Bramford to Twinstead Reinforcement

Document 8.10.6: Applicant's Comments on Other Submissions Received at Deadline 7

Final Issue A
February 2024

Planning Inspectorate Reference: EN020002

Table 1: Structures on Bramford to Twinstead AIL Route

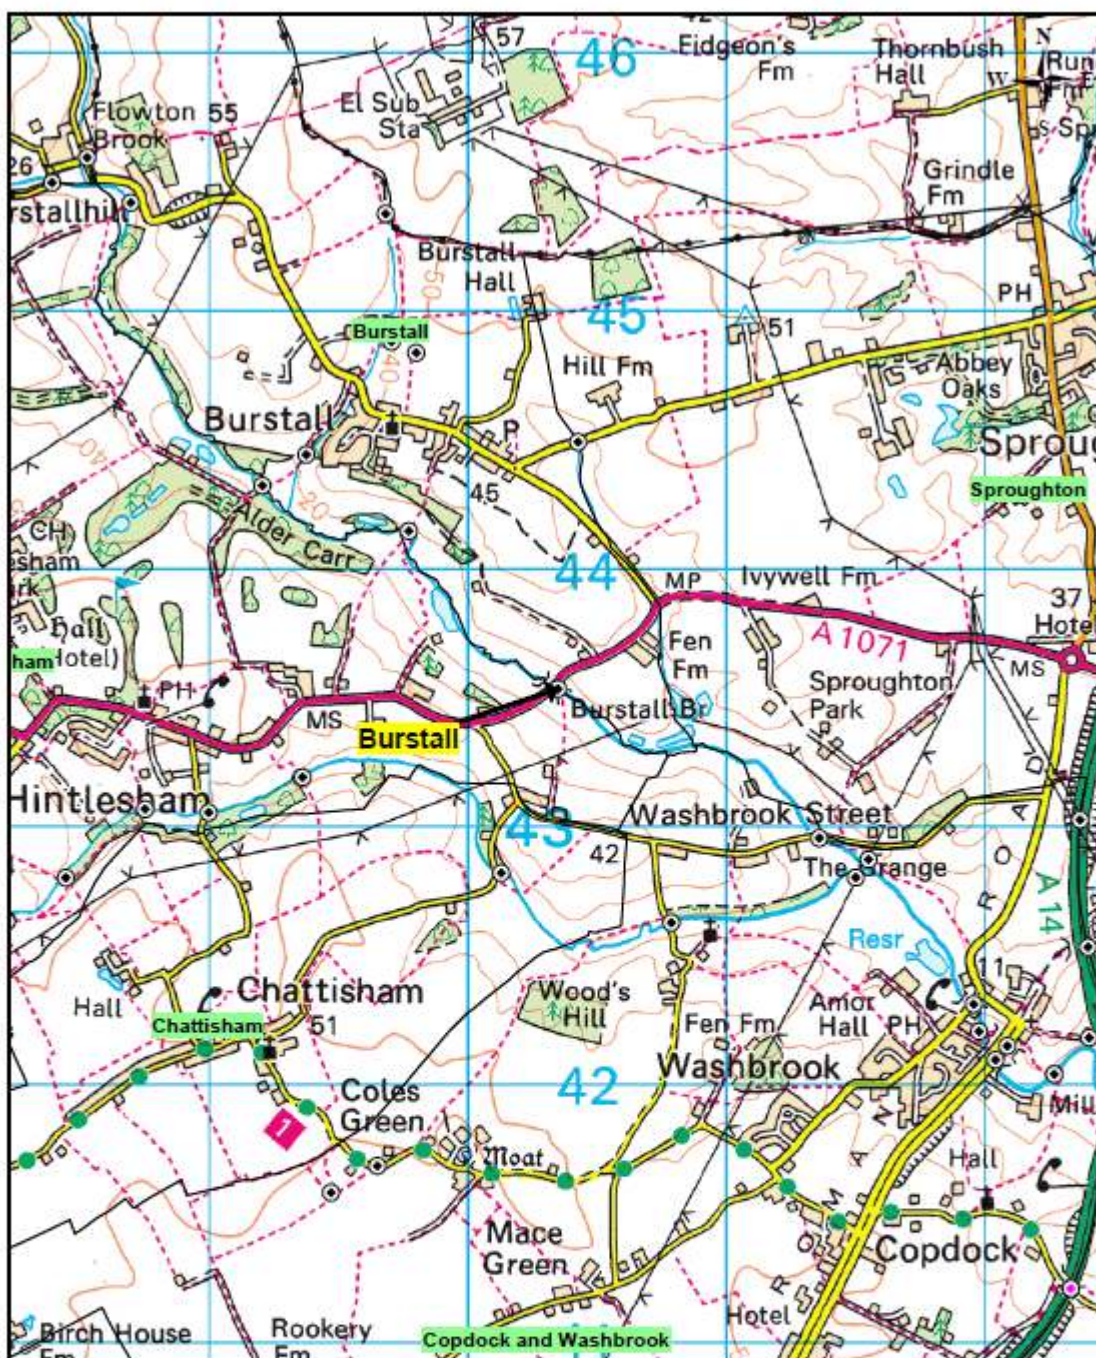
1.18	Action Point 11	SCC has completed a high-level review of structures on the abnormal indivisible load (AIL) routes provided as Figure 2 of the CTMP [REP6-025]. The capacity detail has been confirmed by	The Applicant would refer to its previous response at Deadline 7 [REP7-026] where it agrees that road alignments are fluid and change over time, which is why AIL assessments are required prior to deliveries and need to be undertaken a short period before the
